## PROPOSED LIDL FOODSTORE

Former Hayes Pool and Fitness Centre, Central Avenue, Hayes Town

Response to London Borough of Hillingdon Highways Comments Dated 17/03/2014

| rev | description | date |
|--|-------------|--------|
| 13/0409/TK10 | | C |

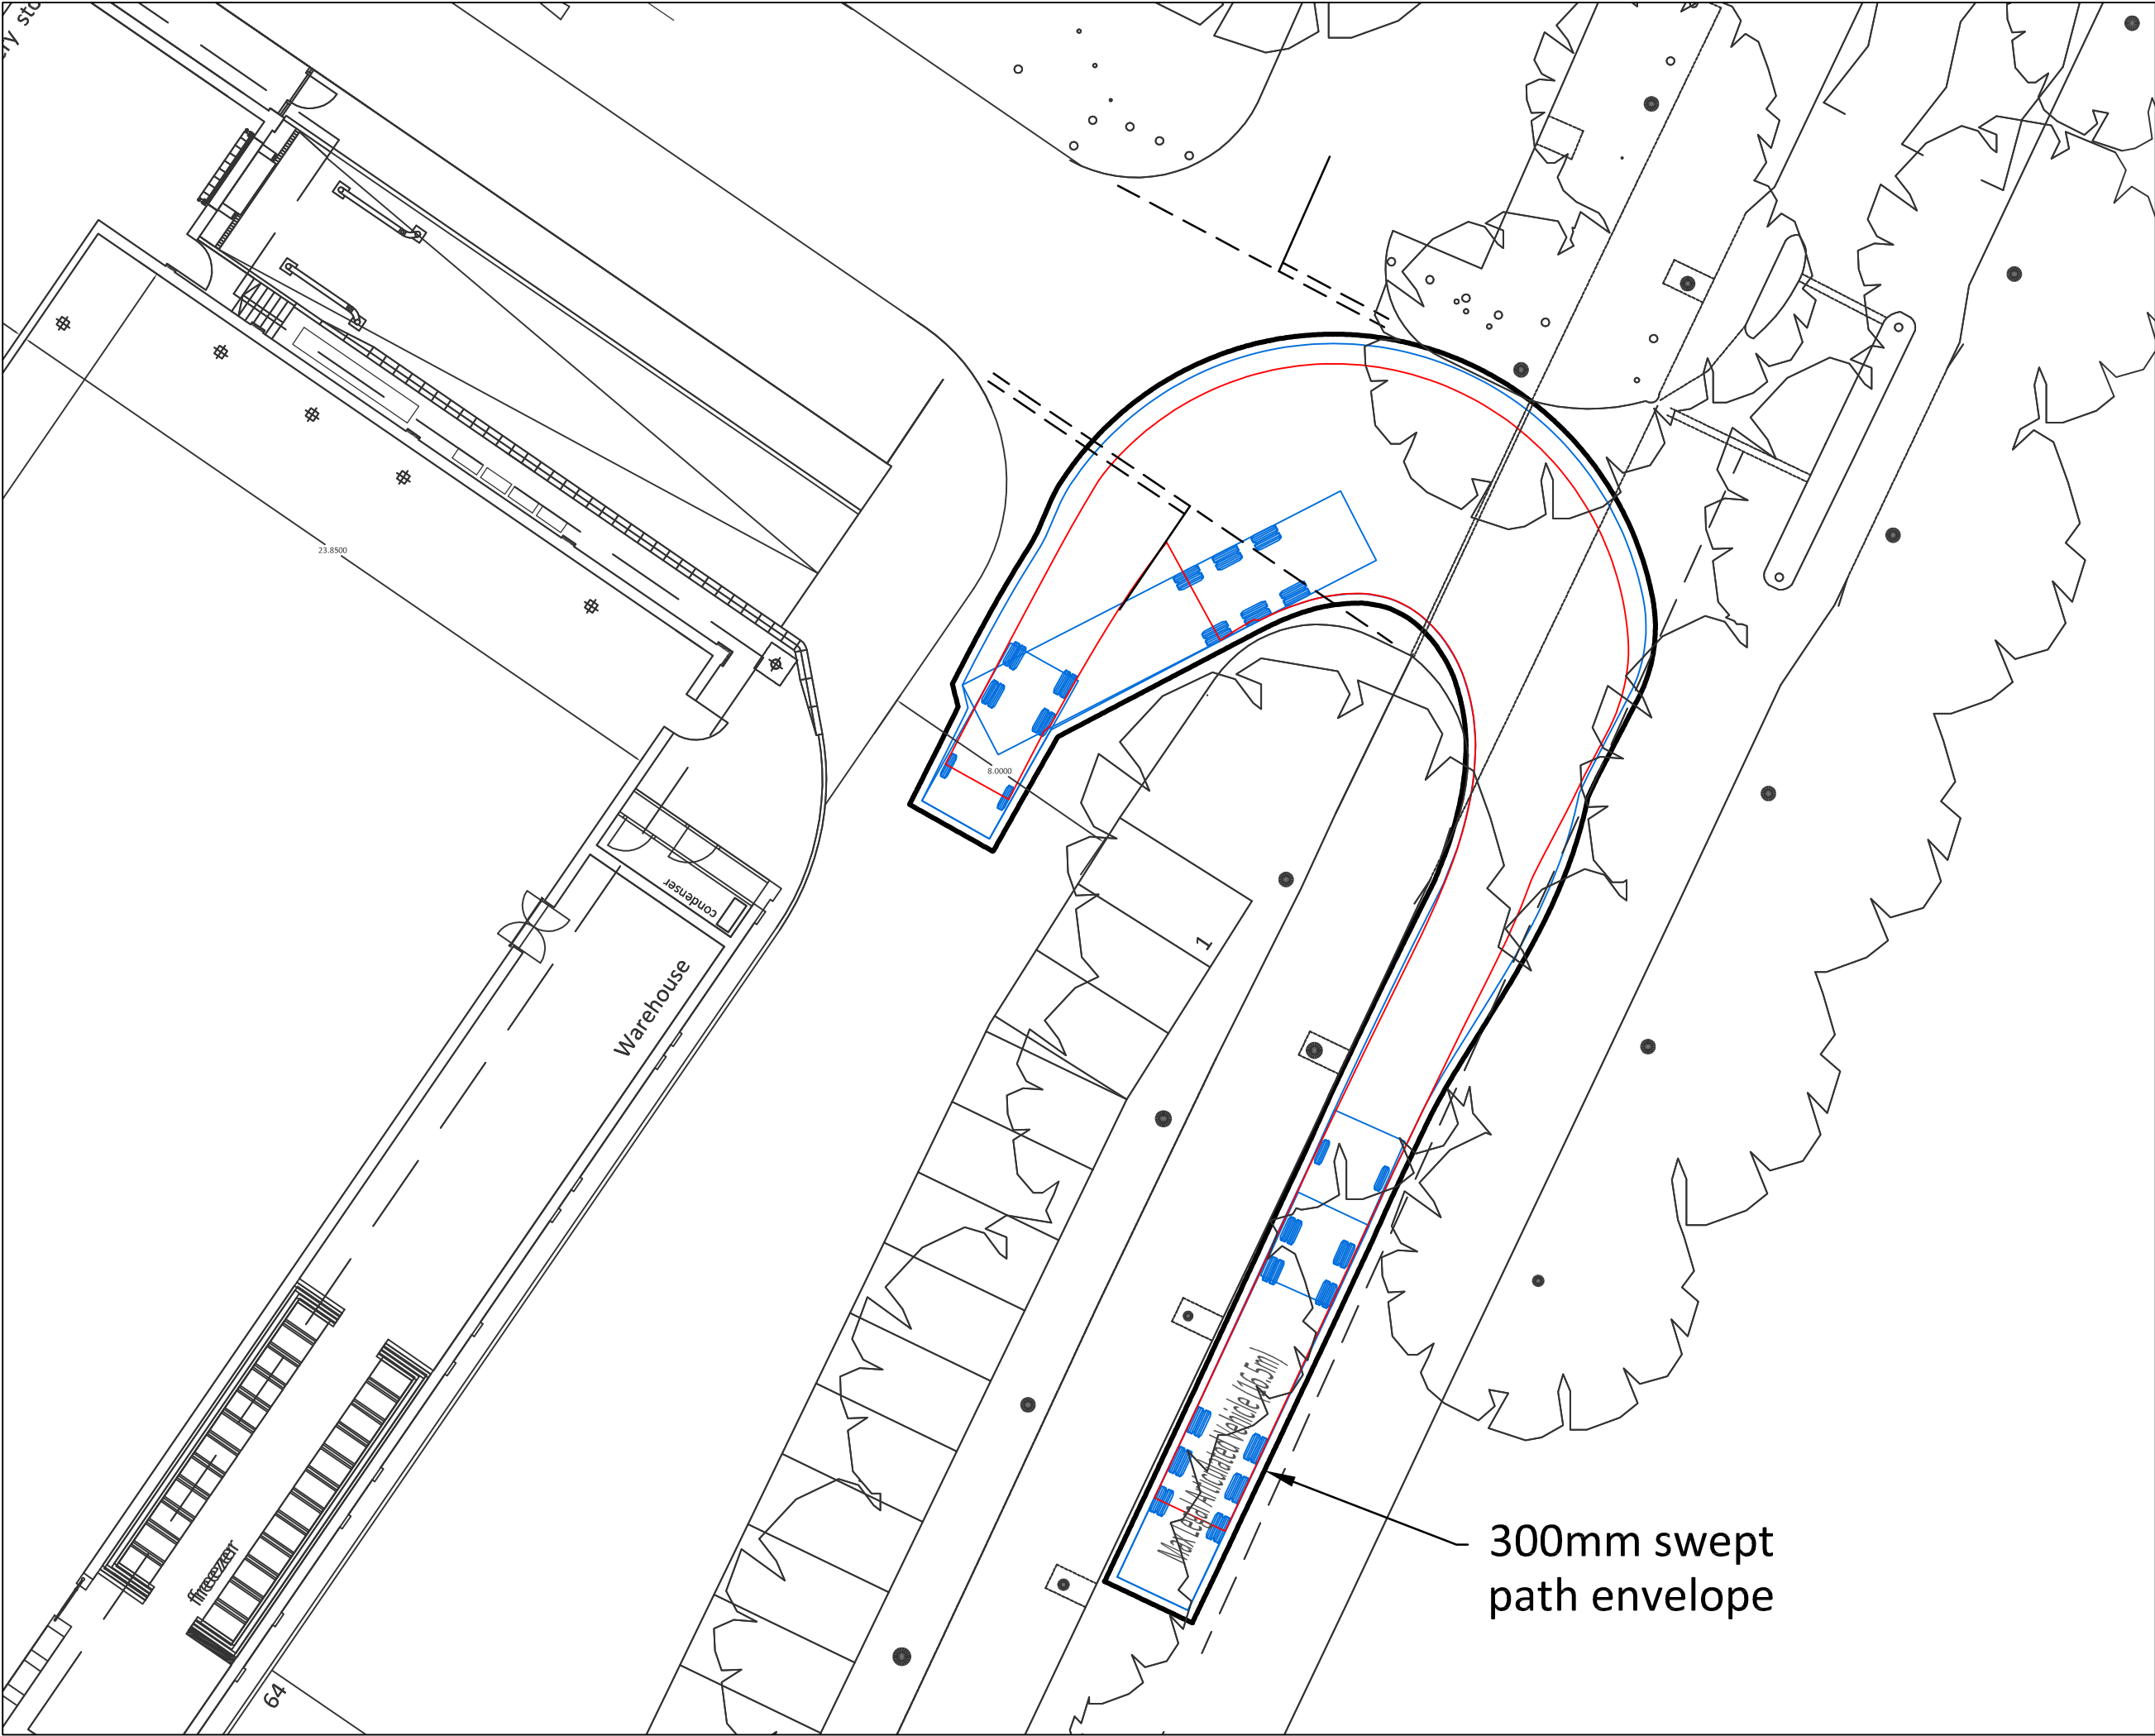
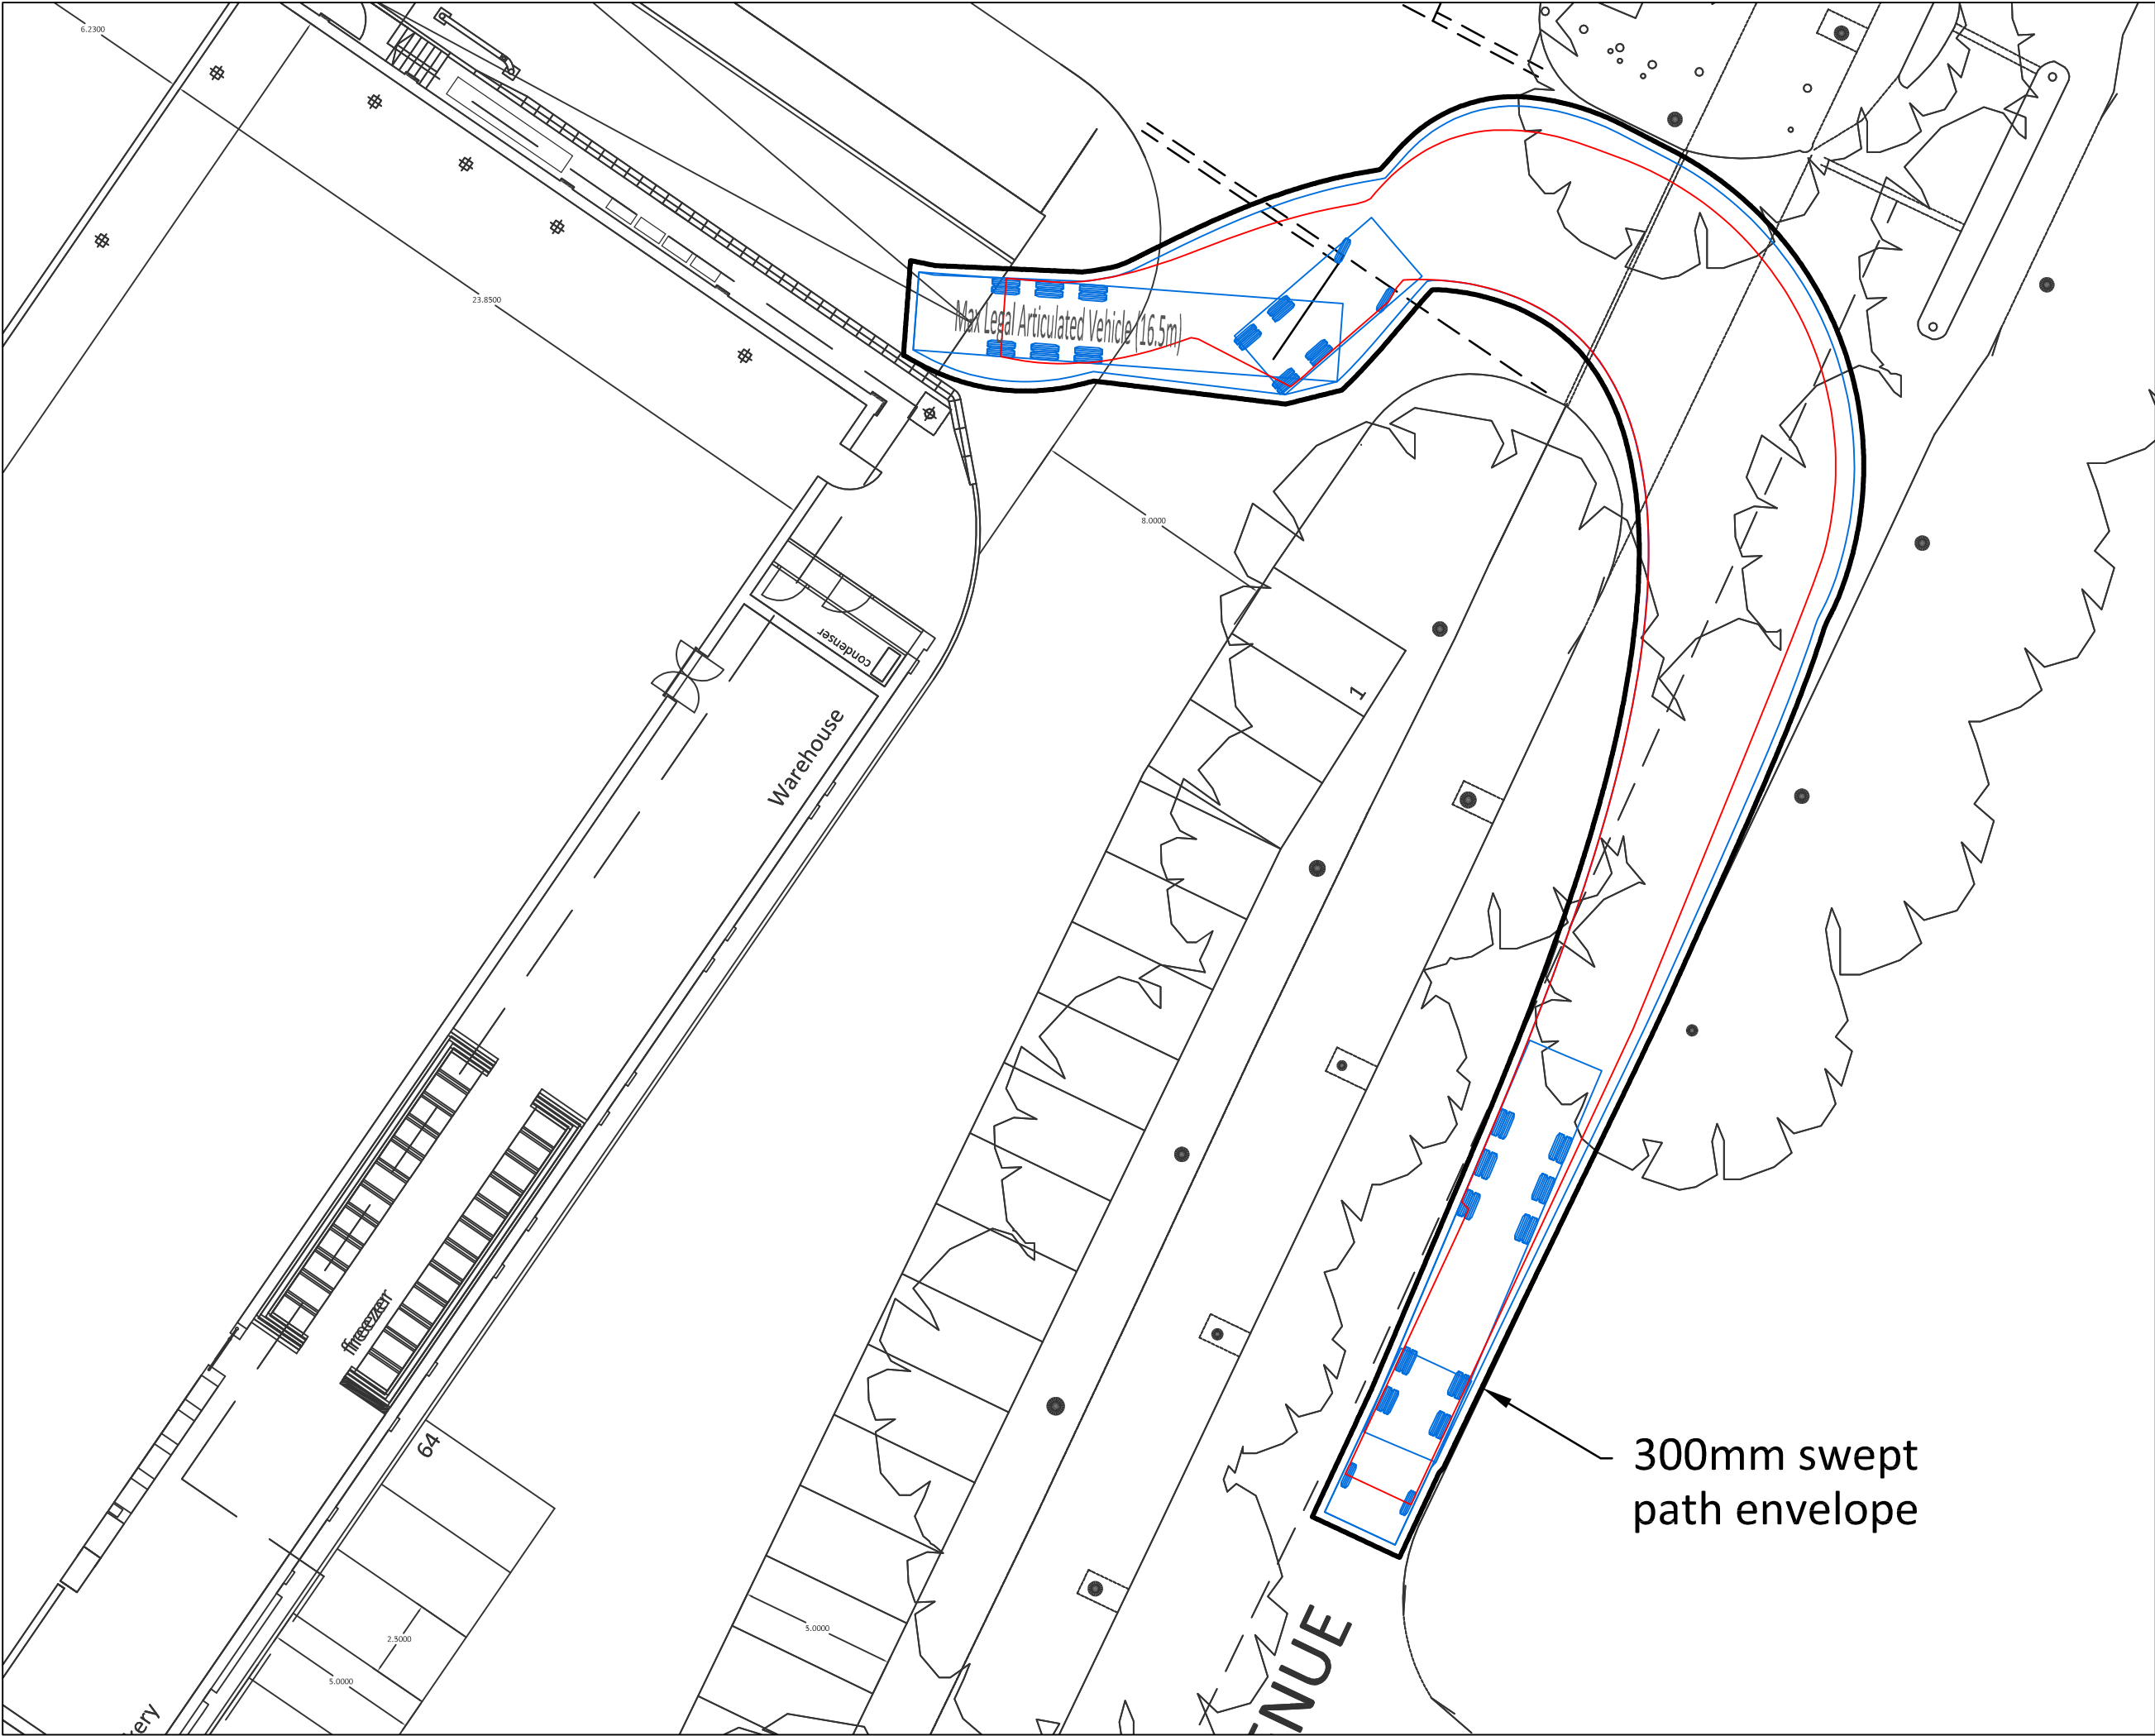
**Comment: The inadequacy of the access off Central Avenue and the site access, which are both not considered suitable for delivery vehicles. It is noted that the joint access also serves a public car park and would potentially provide access for residential development at the remainder of the former Hayes Pool site. Notwithstanding the swept paths submitted, there would be potential conflict between pedestrians and vehicles and reversing delivery lorries. The applicant should therefore devise a suitable access design.**

- 18** Within the proposed site layout, the servicing area is located to the north of the main customer store entrance and away from the bulk of the store car parking which is located to the south of the store within the site. This minimises potential conflicts within the site. The service vehicle manoeuvre takes place in front of 11 car parking spaces within the car park and this will result in the temporary blocking of the access while the manoeuvre is undertaken, but will be clearly visible for anyone in the vicinity and will be of a short duration.

- 19** Further to this, a dedicated pedestrian access to the store will be provided from Central Avenue linking to the store entrance. This will be visible from Central Avenue so that pedestrians heading to the store from the north have a choice of accesses into the Lidl site. In any event, Lidl delivery drivers are required to perform manoeuvres within this type of shared arrangements all over the Lidl store network.
